**Re: Response to Request for Information
SSD-71454709 MOD 1
Mixed-use Development including Affordable Housing
30-34 Padstow Parade & 10 Faraday Road, Padstow**

Table 1: Response to Council Comments

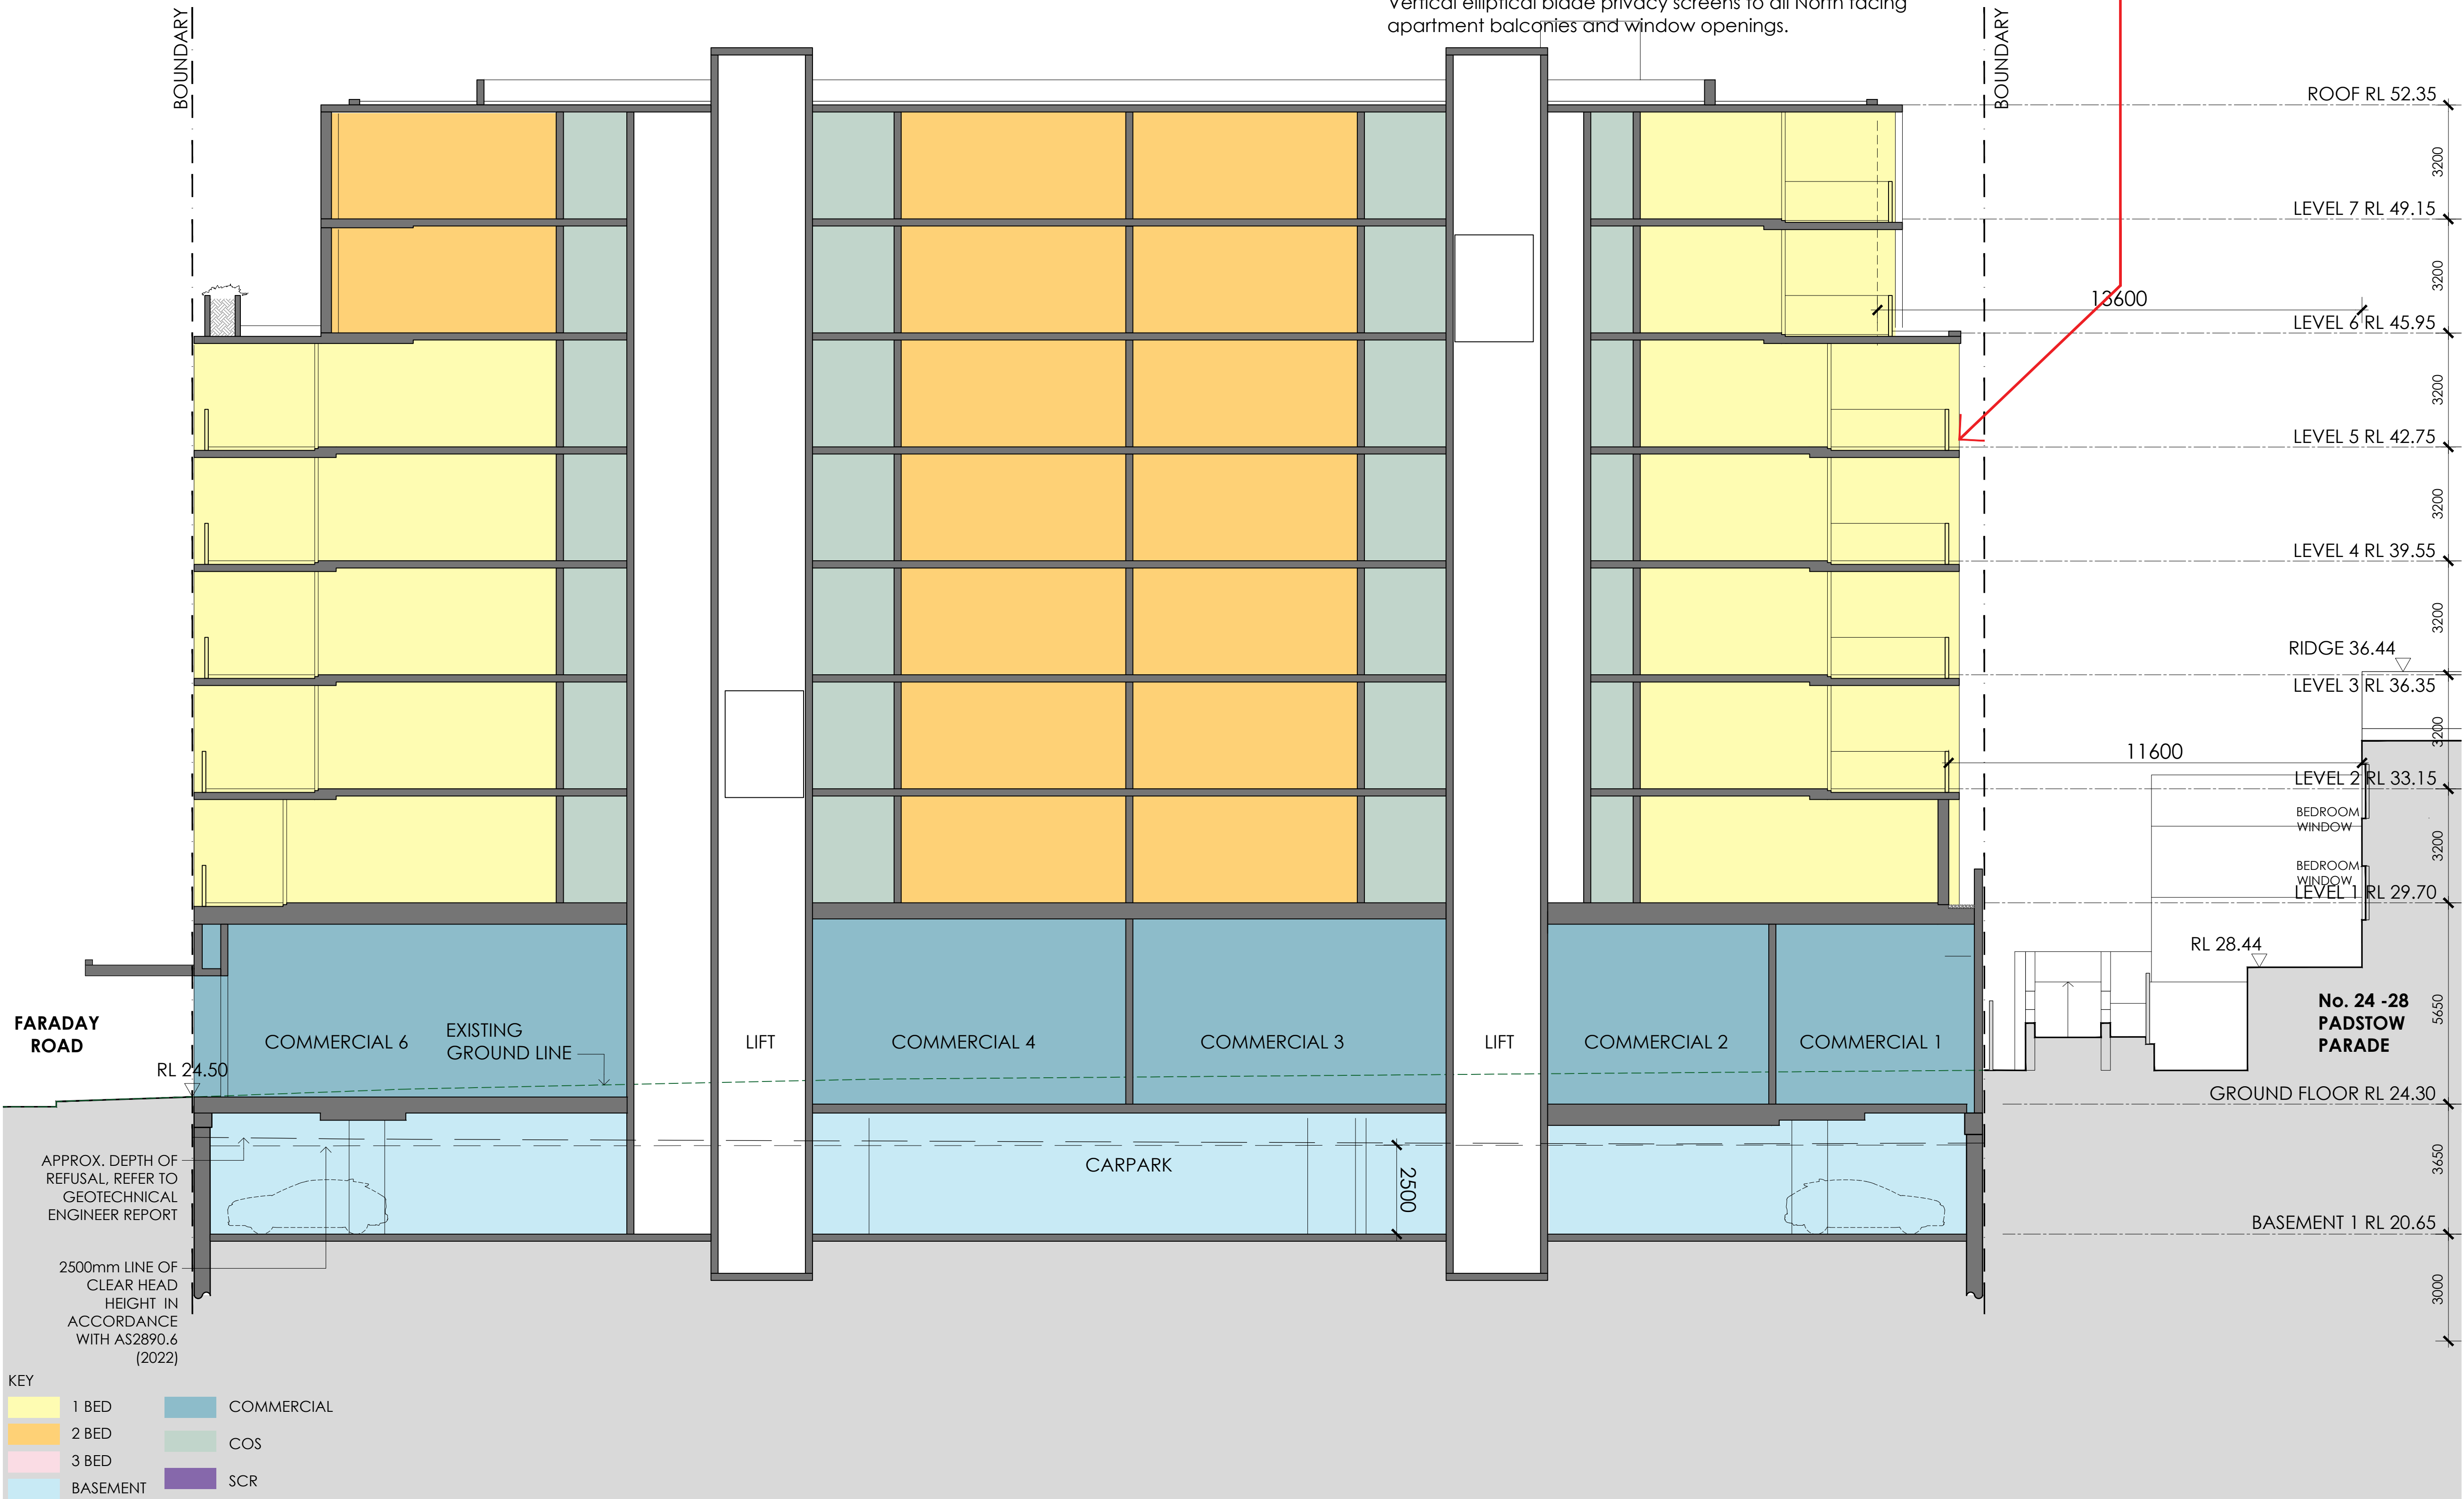
Summary of Council comments	Response
Podium Design	
The increased height of the 'brick base' results in a poor design outcome and is now visually dominant and provides no articulation. This is particularly concerning as it is close to the pedestrian scale and would dominate the façades of the building when viewed from ground level in the public domain. The modified design does not promote design excellence nor a high quality finish. Further work to articulate this base is needed.	Disagree. The increase in the height of the brick façade at the ground level by just 1.45m does not result in an overly dominant building base. The element would present as just 1.5 storeys in height, and given the likely future surrounding context, where the planning controls expect a street wall height of 4 storeys, this would not be an overly dominant visual element. Further, the brick base is highly articulated by extensive openings on the street facing facades, recessed elements on Padstow Parade, and articulated awnings on both streets which break up the massing visually, especially as viewed by pedestrians at ground level in the public domain.

CARPARK RAMP GROUND FLOOR PLAN

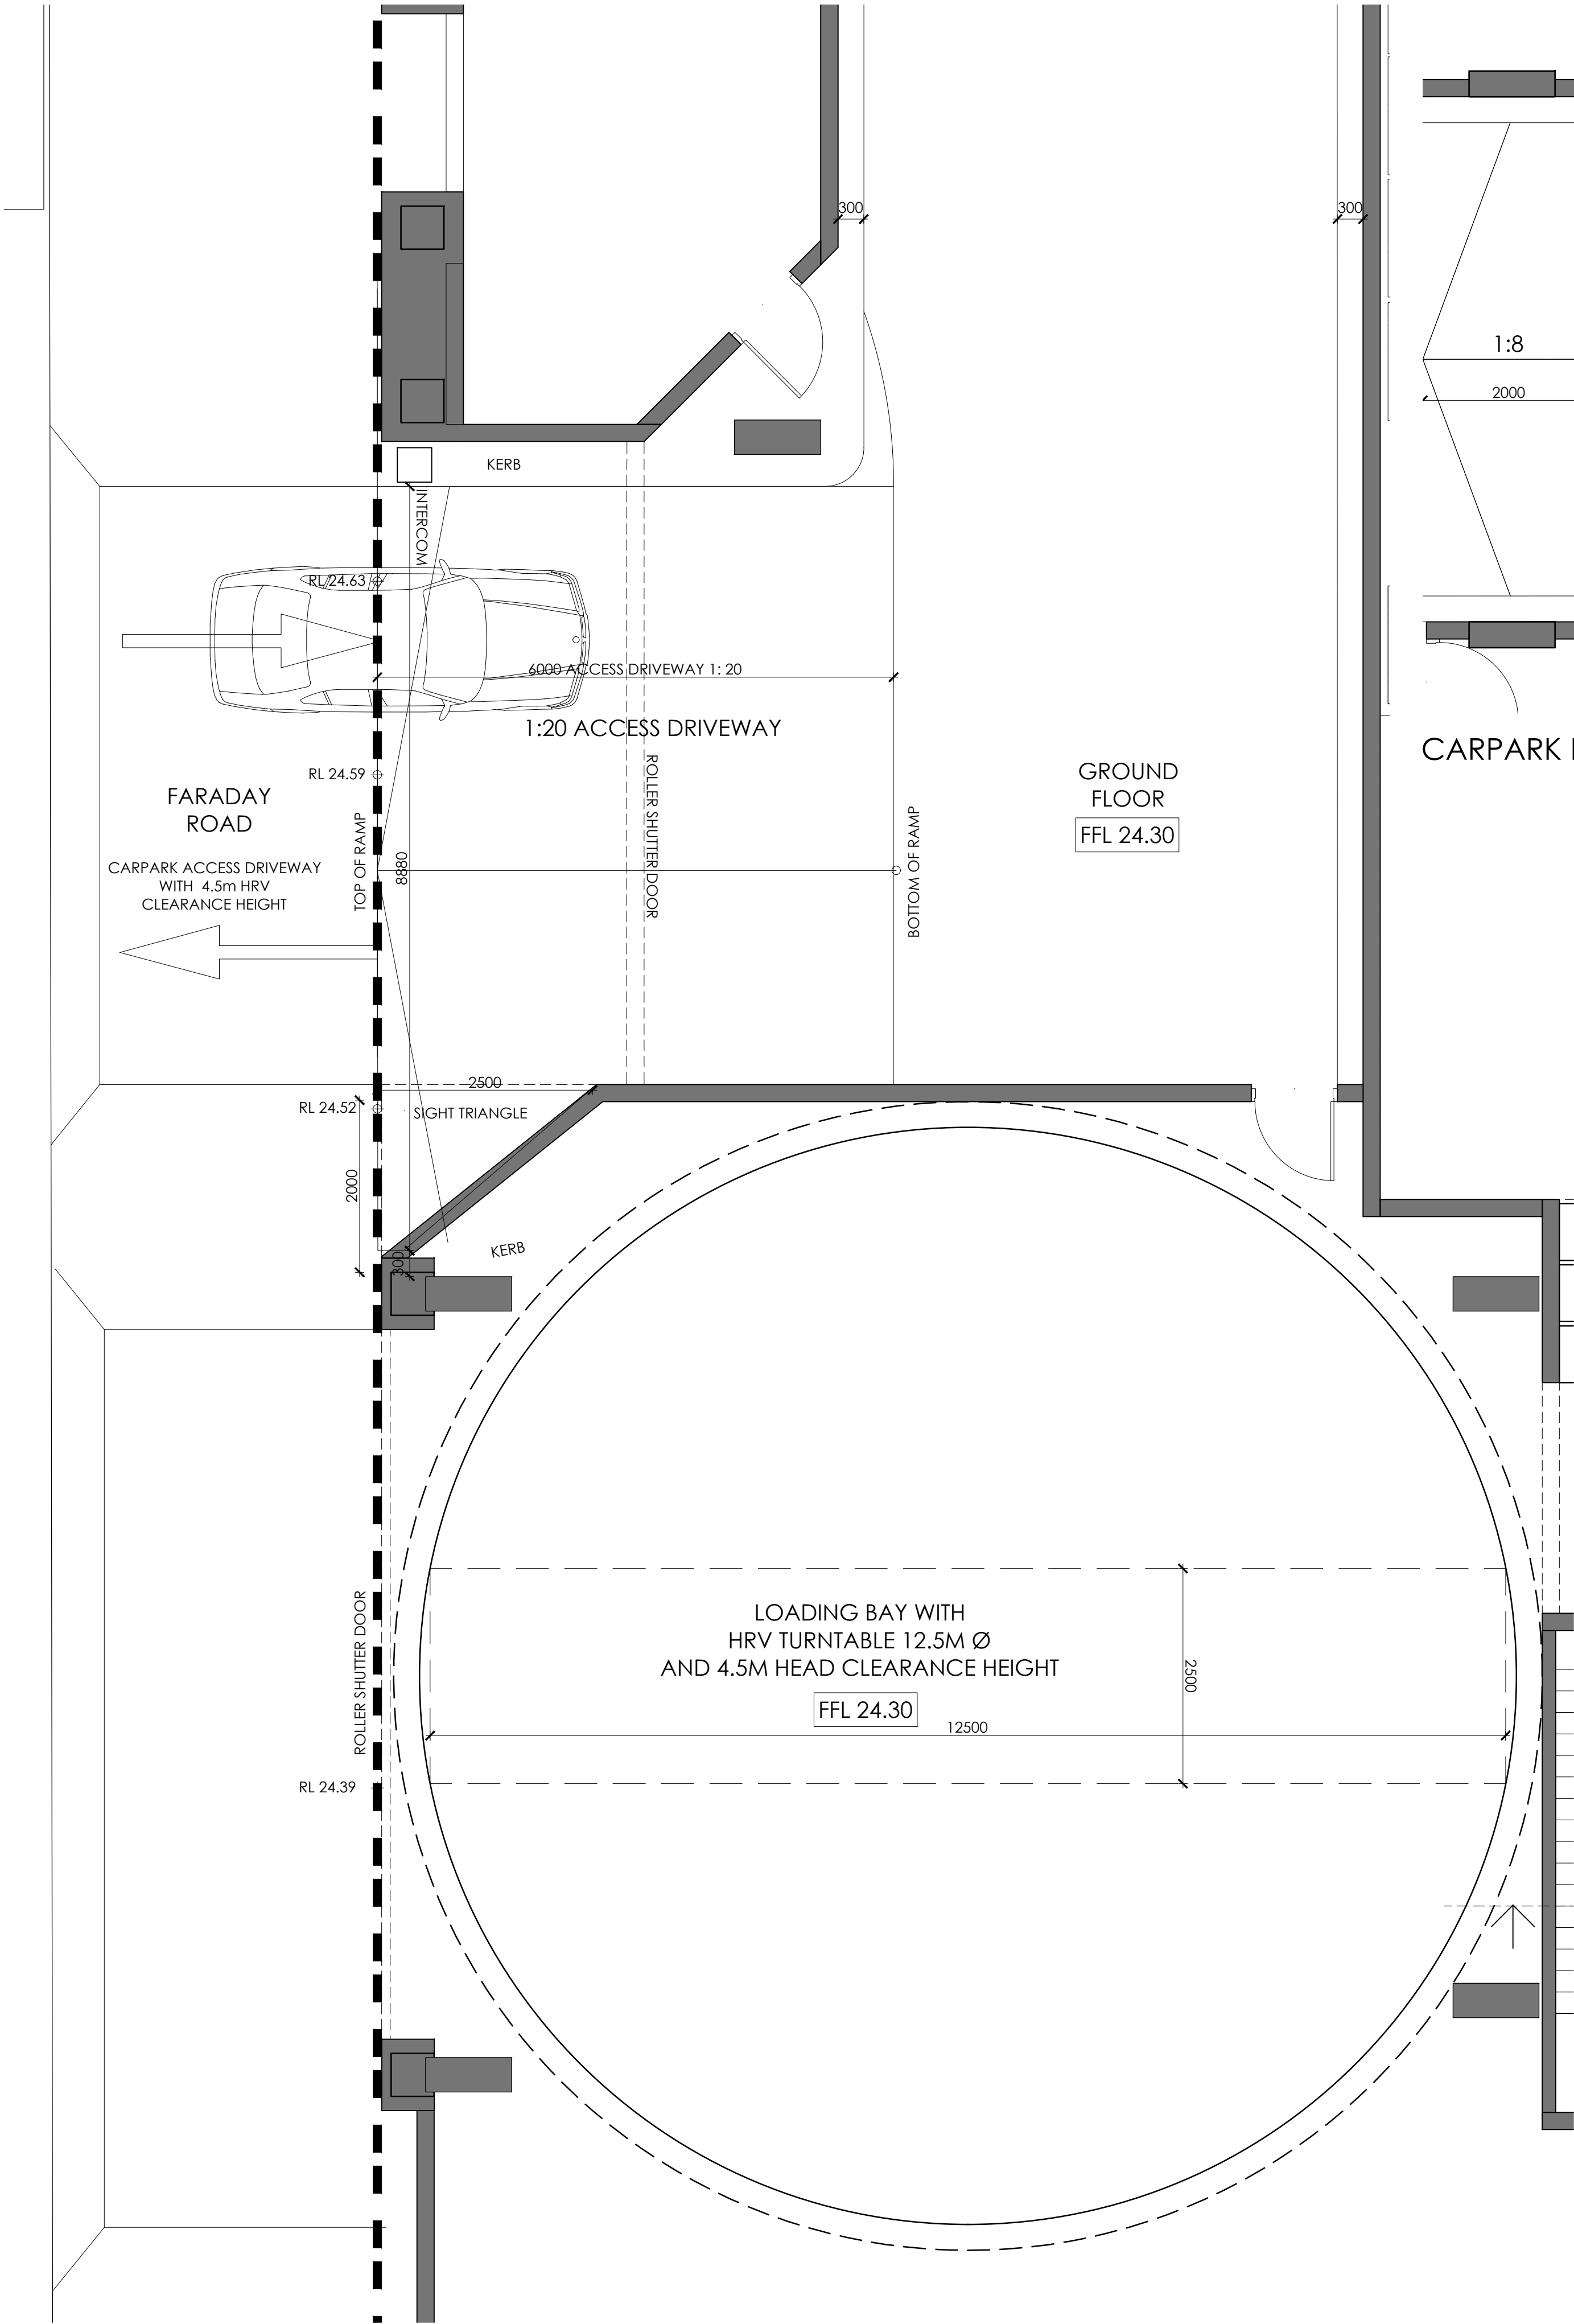
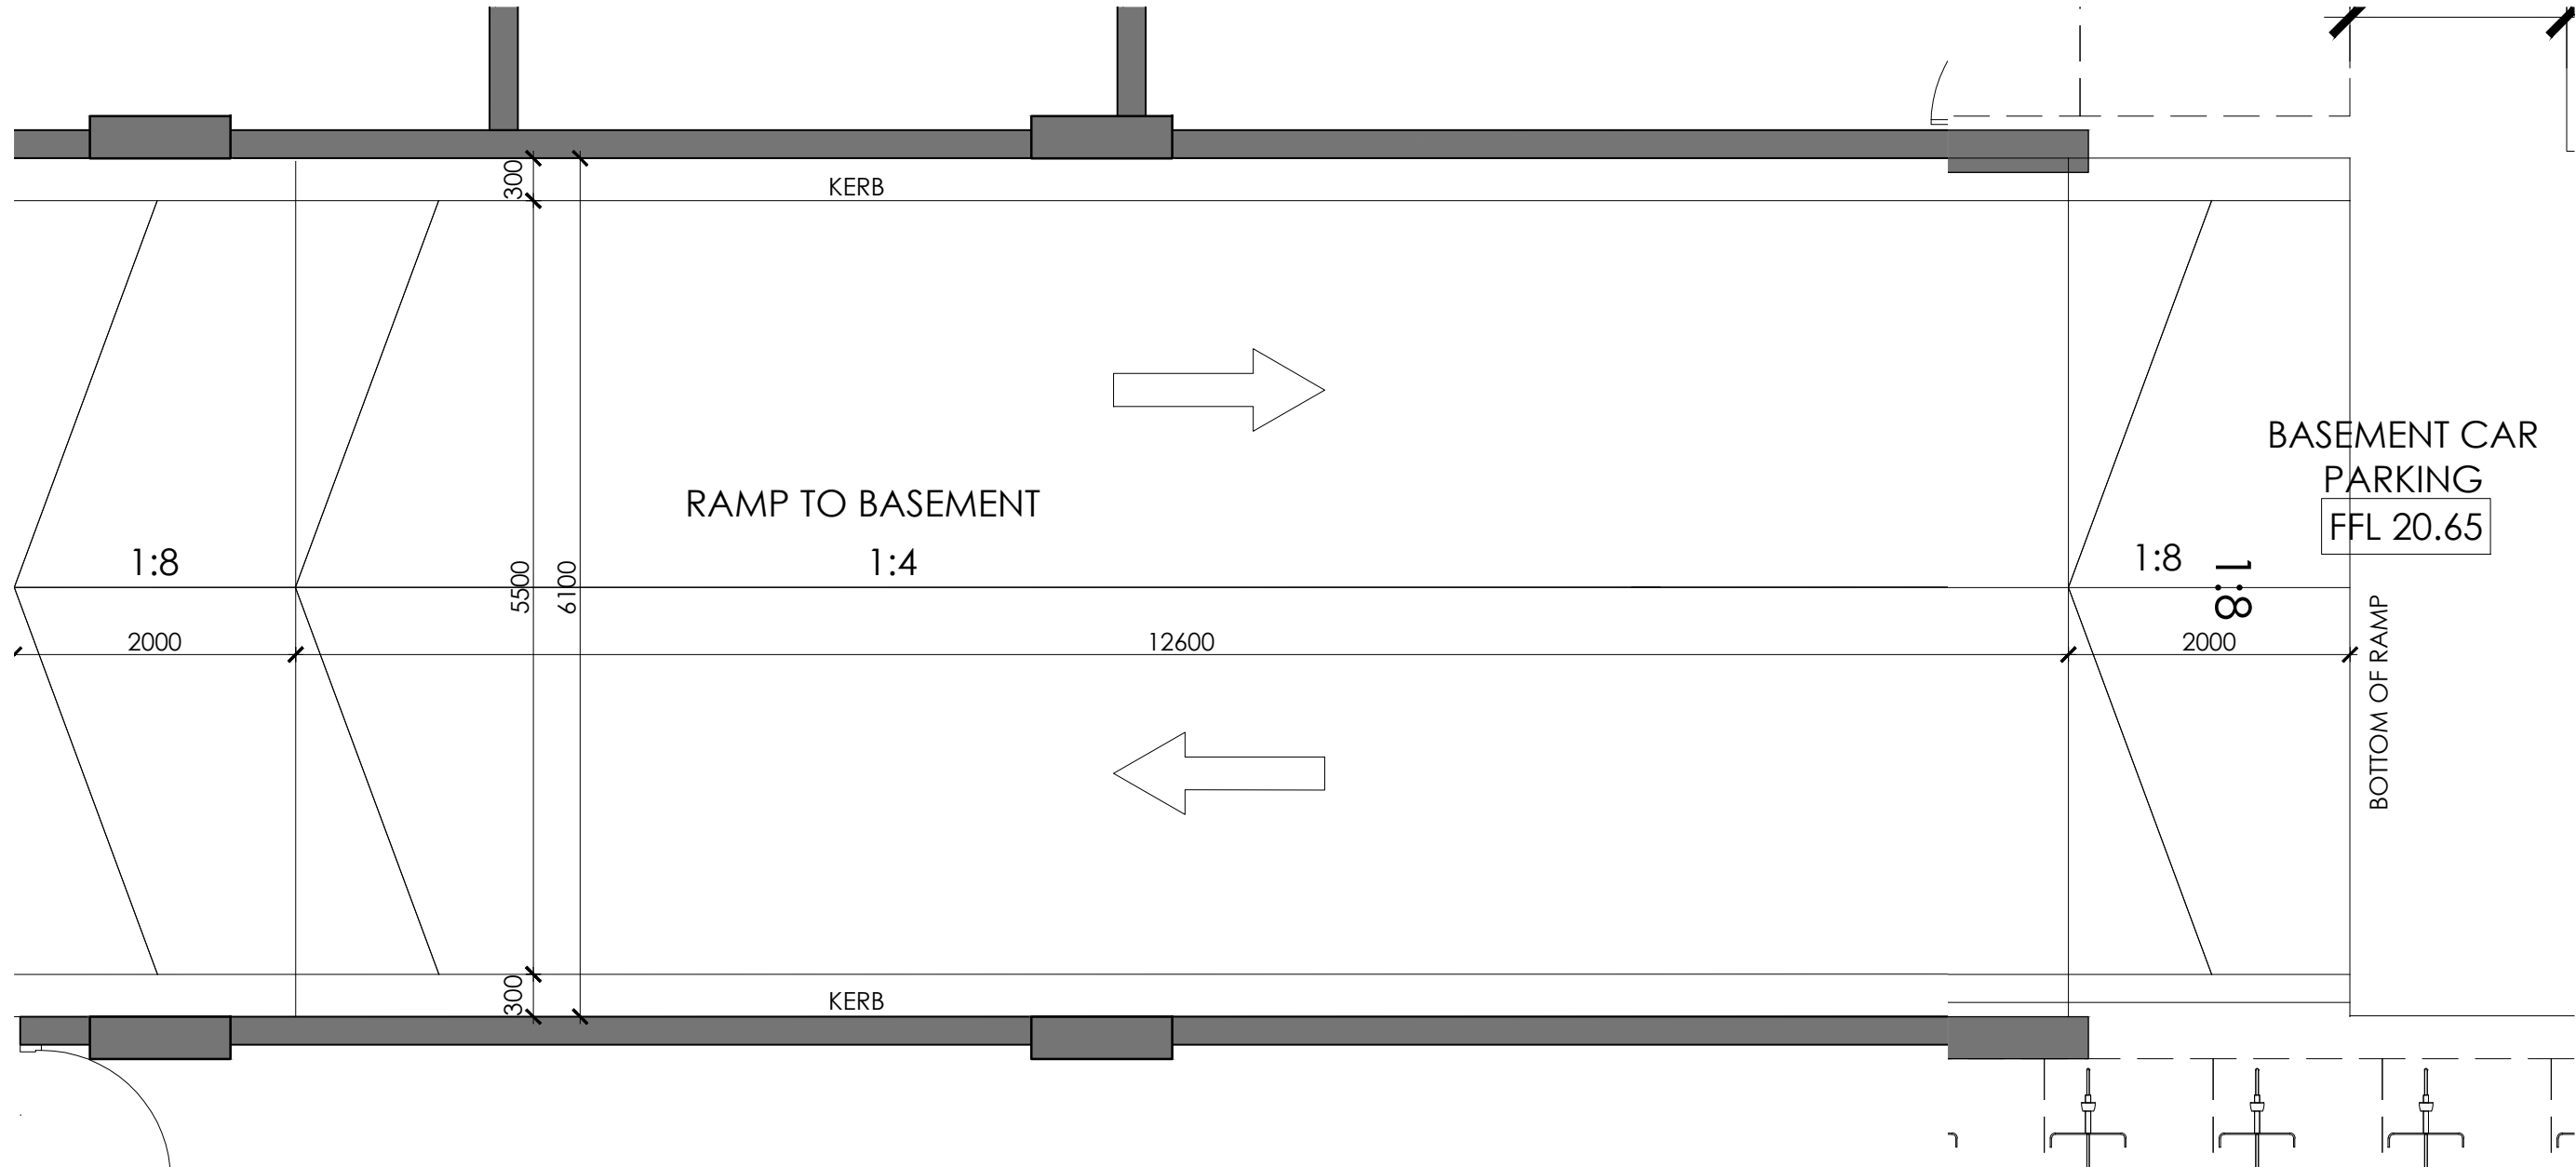
utilising the entire circulation roadway width and fails to comply with AS2890.1.

- The traffic report has failed to provide details on traffic management between the VFC and basement ramp on the ground level and the traffic measures to be implemented to manage two-way traffic flow being funnelled into a one-way circulation roadway.
- The proposed tree planting near the proposed carpark VFC shall be removed to allow for better manoeuvrability of B99 vehicles.
- The proposed location of the relocated roller shutter door will result in loss of internal queueing space within the ground floor. Therefore, queueing analysis will need to be conducted to ascertain the impacts along Faraday Road.
- The proposed intercom location is located on the passenger side of vehicles and needs to be located on the driver side.

roadway can still function as two-way in compliance with AS2890.1.

- A convex mirror will also be provided to assist with sighting of on-coming vehicles.
- The swept paths indicate the proposed street tree planting does not impede access to the site and therefore removal of the tree is not required.
- It is now proposed that the roller shutter door at the driveway entrance be kept open during commercial operating hours providing direct access to the basement and therefore no queueing will occur at these times.
- At night the shutter door will be closed but openable by remote control by residents, again ensuring no queueing.
- The intercom therefore will not be needed. Nevertheless, it is proposed to be retained as indicated to cover very rare events where access is required by a person who does not have a remote control.
